From: [Aaron Webster](#)
To: [Jeremiah Cromie](#)
Cc: [Adam Osbekoff](#); [Steven Moses](#)
Subject: RE: LP-23-00002 Tumbling Ridge - Notice of Application
Date: Thursday, May 18, 2023 2:51:44 PM

RE: LP-23-00002 Tumbling Ridge

RE: LPF-23-00002 Tumbling Ridge Plat

TO: All Staff
FROM: Public Works Plan Review Team
DATE: June 5th, 2023
SUBJECT: LP-23-00002 Tumbling Ridge

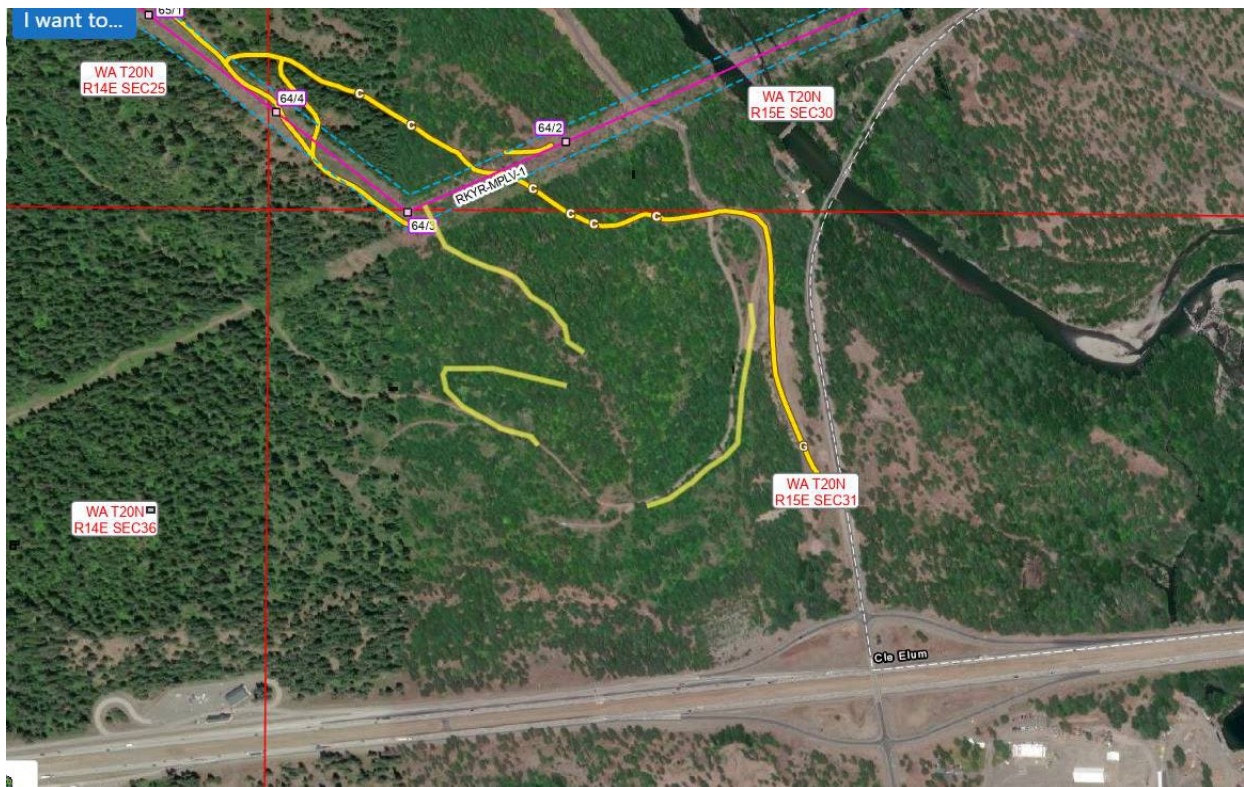
It appears the proposed use for new project Tumbling Ridge Long Plat (LP-23-00002) appears to impact Bonneville Power Administration's (BPA) access roads and access right-of-way.

BPA's rights need to be reserved for BPA's use. If any of the applicant's uses will impact BPA's access road and/or access rights, they will need to reach out and work with BPA to retain BPA's access rights and establish routes of travel, prior to any work or development taking place.

Please see the image below as a visual aid.

TUMBLING RIDGE PRELIMINARY PLAT

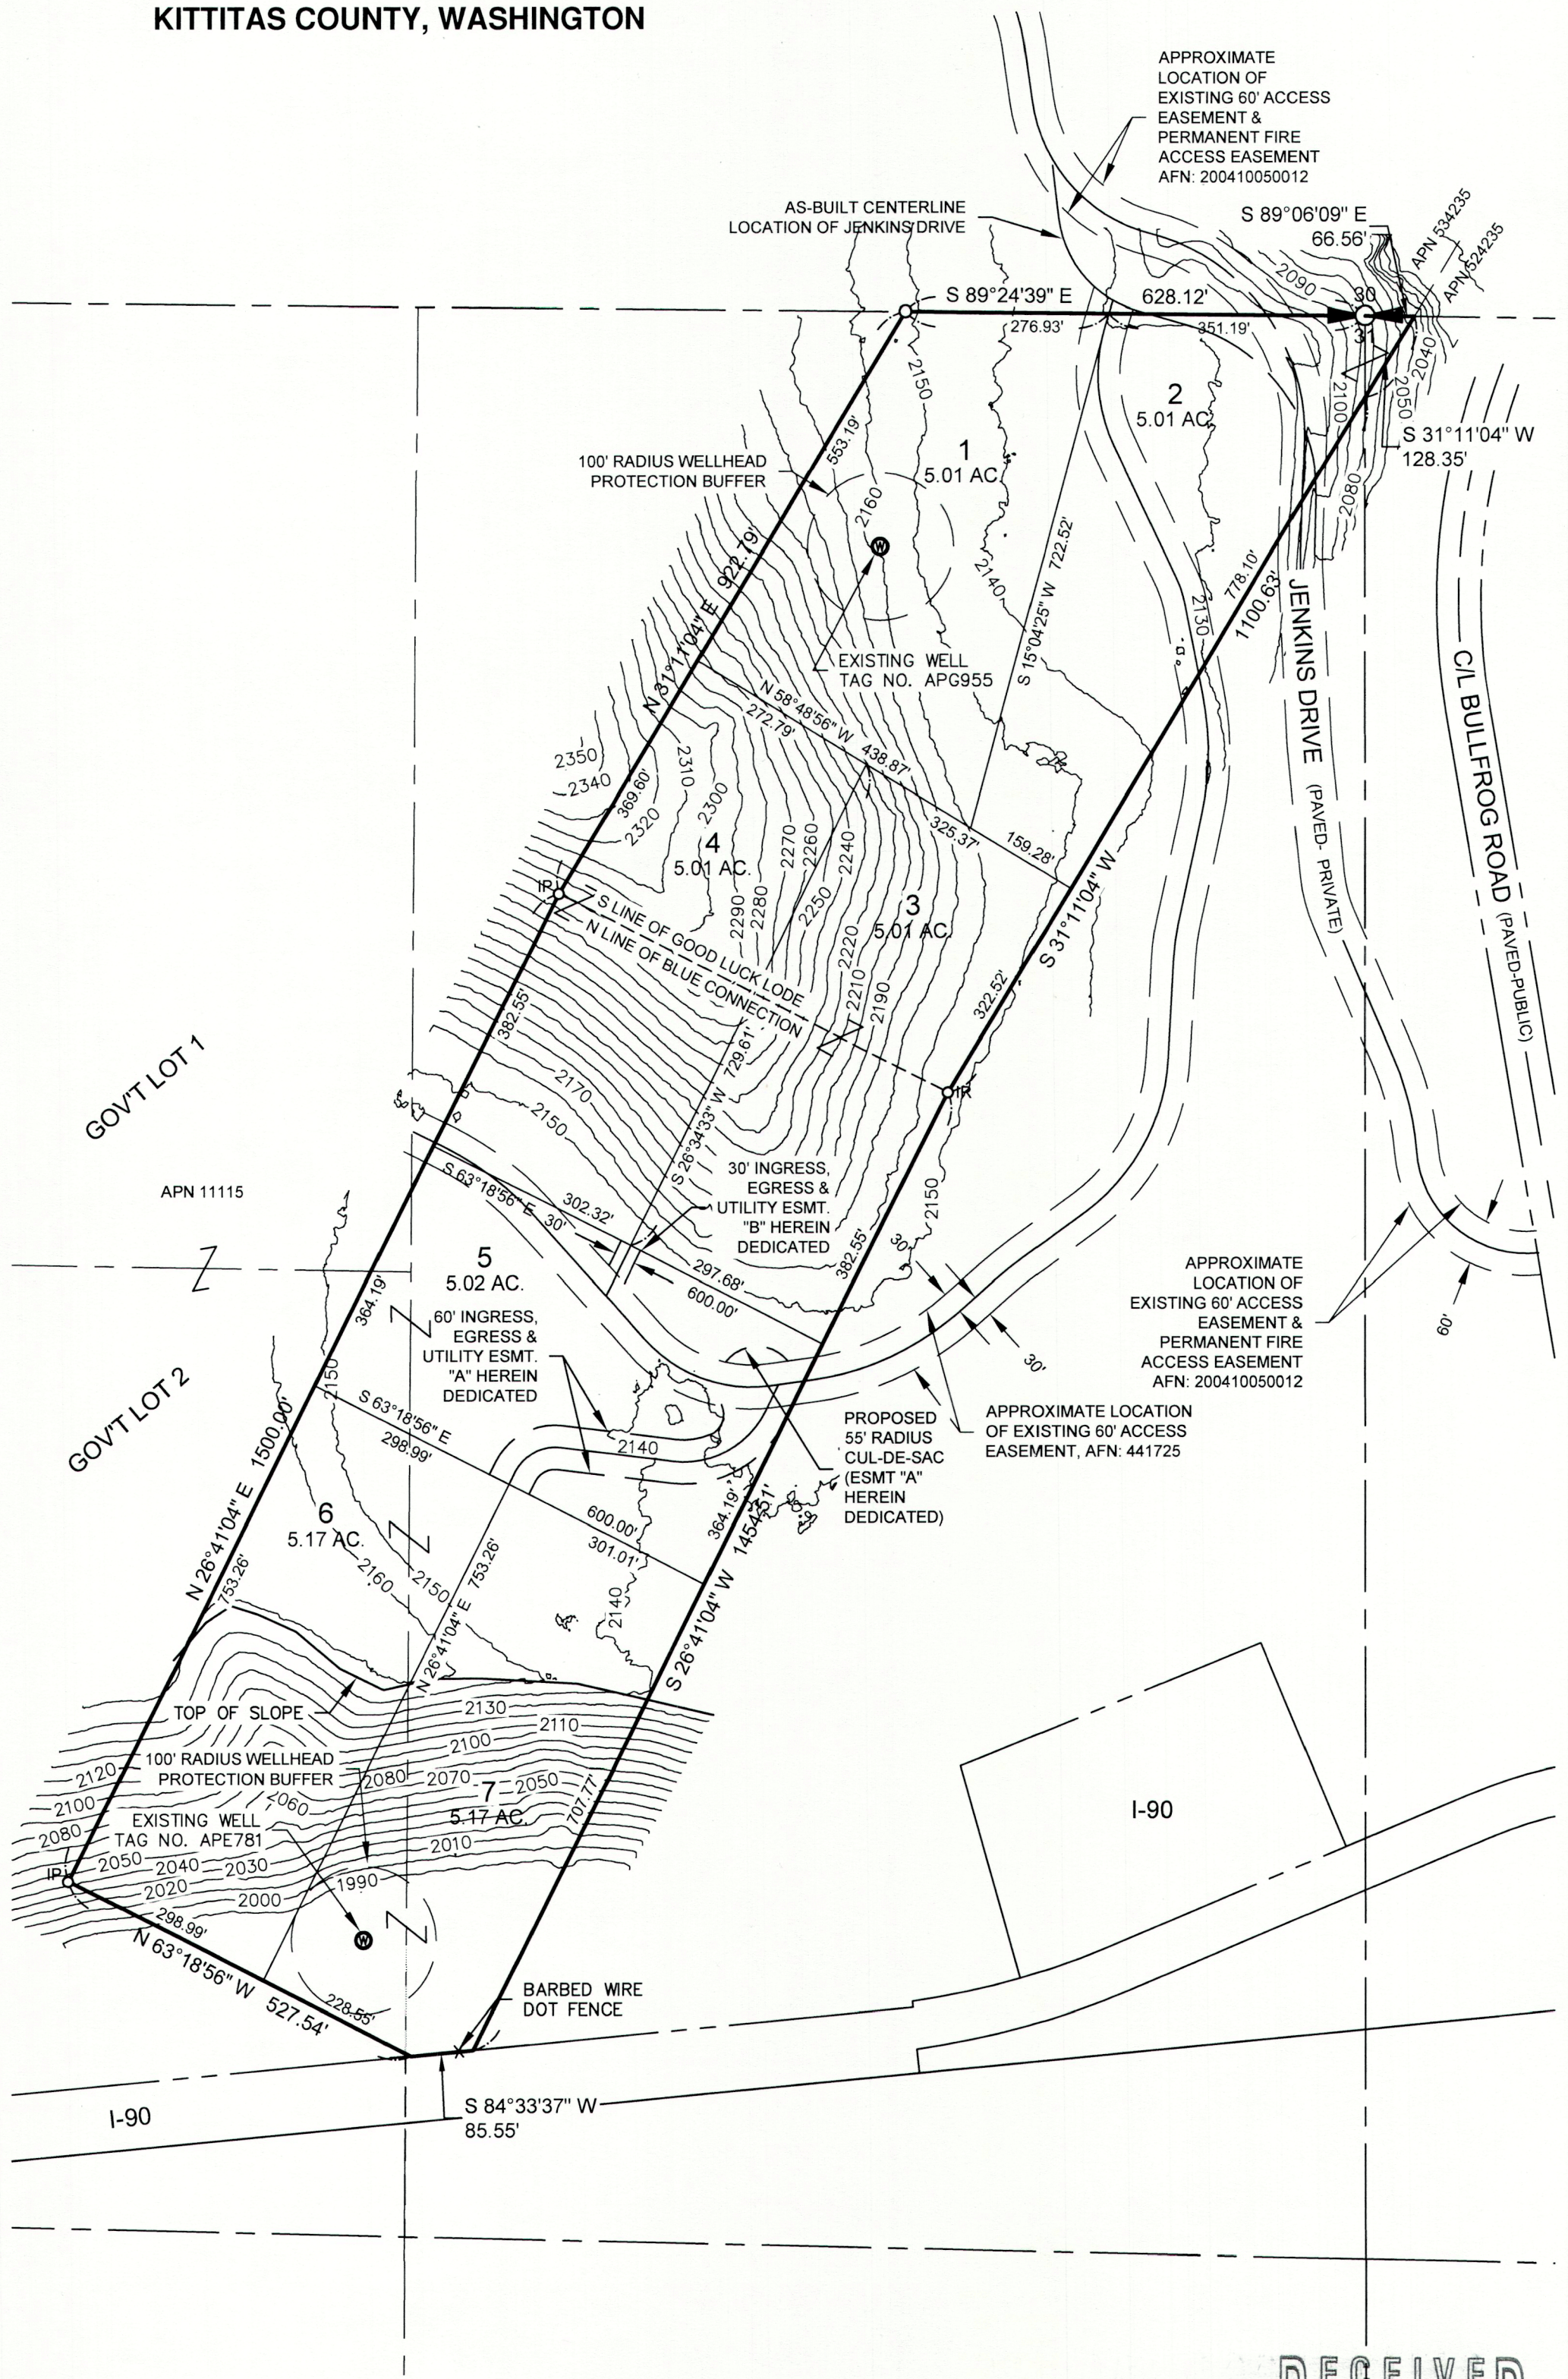
There is a road that passes through this plat to access WDFW lands to the west, namely proposed Lots 4 and 5. WDFW needs to maintain access along this road if the parcel is split and the residents need to be aware that they are living next to public land and the responsibility that entails. If this plat is approved, please work with the LT Murray manager Shaun Morrison to ensure that access is maintained for WDFW management of our land.

WDFW has concerns about the approval of Lot 2. The northern half of Lot 2 is situated above the Cle Elum River an important waterbody for aquatic life. Steep slopes in the northern half of this parcel could lead to landslides entering the Cle Elum River if proper precautionary measures are not taken. WDFW requests that if this Long Plat is approved, a Geotechnical report be required before any land clearing activities including tree removal is approved on the northern half of proposed Lot 2. The Geotechnical report should demonstrate where ground clearing could occur without causing disturbance to the steep slopes and increasing the risk of a landslide.

SURVEY	1. Site map does not meet the requirements of WAC 332-130-145. (JT)
TRANSPORTATION CONCURRENCY	1. Concurrency evaluation is required per KCC 12.10.040
FLOOD	Parcel #s 952139 and 952140 are not located in the special flood hazard area (100-year floodplain).
WATER MITIGATION/ METERING	<p>For the proposed plat, the applicant must provide legal water availability for all new uses on the proposed lots of this project, which can be provided through mitigation certificates. Plats are not eligible for the Kittitas County Water Bank, water mitigation must be purchased from a private water bank.</p> <p>Prior to final plat approval and recording, the following conditions shall be met:</p> <p>In accordance with KCC Chapter 13.35.027, the applicant shall provide one of the following documents before final plat approval:</p> <ol style="list-style-type: none"> 1. A letter from a water purveyor stating that the purveyor has adequate water rights and will provide the necessary water for the new use; 2. An adequate water right for the proposed new use; or 3. A certificate of water budget neutrality from the Department of Ecology or other adequate interest in water rights from a water bank. <p>All applicants for land divisions shall also submit information on "proximate parcels" held in "common ownership" as those terms are defined in WAC 173-539A-030 and otherwise demonstrate how the proposed new use will not violate RCW 90.44.050 as currently existing or hereafter amended.</p> <p>Failure to obtain mitigation before commencement of an activity requiring mitigation shall be a code violation subject to enforcement under Title 18 KCC.</p> <p>Final Plat Notes</p> <p>The following notes shall be placed on the face of the plat:</p> <p>C-1 "Metering is required for all new uses of domestic water for residential well connections and usage must be recorded in a manner consistent with Kittitas County Code Chapter 13.35.027 and Ecology regulations."</p> <p>C-2 "The approval of this division of land provides no guarantee that use of water under the ground water exemption (RCW 90.44.050) for this plat or any portion thereof will not be subject to curtailment by the Department of Ecology or a court of law."</p>
